**KIRKLEES COUNCIL
TOWN AND COUNTRY PLANNING ACT 1990
HIGHWAYS DEVELOPMENT MANAGEMENT**

PLANNING REF 2017/62/90481/E0/ET
CATEGORY Minor

PROPOSAL	CHANGE OF USE OF UNITS 2 & 3 TO A1 & A3 USES,EXTERNAL ALTERATIONS TO UNITS 2 & 3,REVISED ACCESS,PARKING AND LANDSCAPING,LAYOUT OF SUBSTATION	HDC Ref. No.	K10-12SW/3
LOCATION	FOUNTAIN COURT HUDDERSFIELD ROAD ROBERTTOWN LIVERSEDGE WF15 7QQ	Highway Officer	Mark Berry
APPLICANT	ROBERT HALSTEAD CHARTERED SURVEYOR	O. S. Ref.	200 222
		Date Received	23/03/2017
		Target Date	13/04/2017
		Date Returned	04/05/2017
		Decision	
		Route No.	A62
		Road Name	HUDDERSFIELD ROAD
		Adopted	Yes
		Footpath	No
		Highway scheme	No

Proposed Development

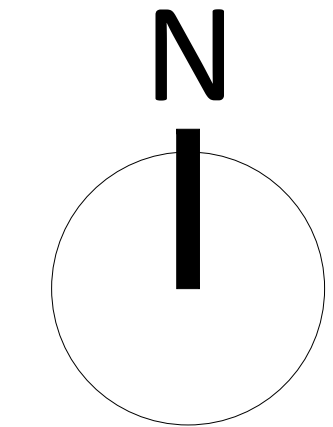
Highways would agree with the applicants that the existing access is narrow for vehicles turning into the site if another vehicle is waiting to turn right. However the proposed widening of the existing access is a concern in that the existing access only has a single lane exit, whereas this proposal will provide two. If two cars are waiting alongside each other, will they obstruct each other's sight lines. The increase in width of the access may also be a problem for pedestrians on Huddersfield Road crossing the proposed access.

Highways consider that the applicants should amend their proposal access designs.

Notwithstanding the details shown on the approved plan 10/K16/5991/03e, a scheme detailing arrangements and specification for layout of the proposed site access shall be submitted to and approved in writing by the Local Planning Authority. The development shall not be brought into use until the approved scheme has been implemented and thereafter retained throughout the lifetime of the development.
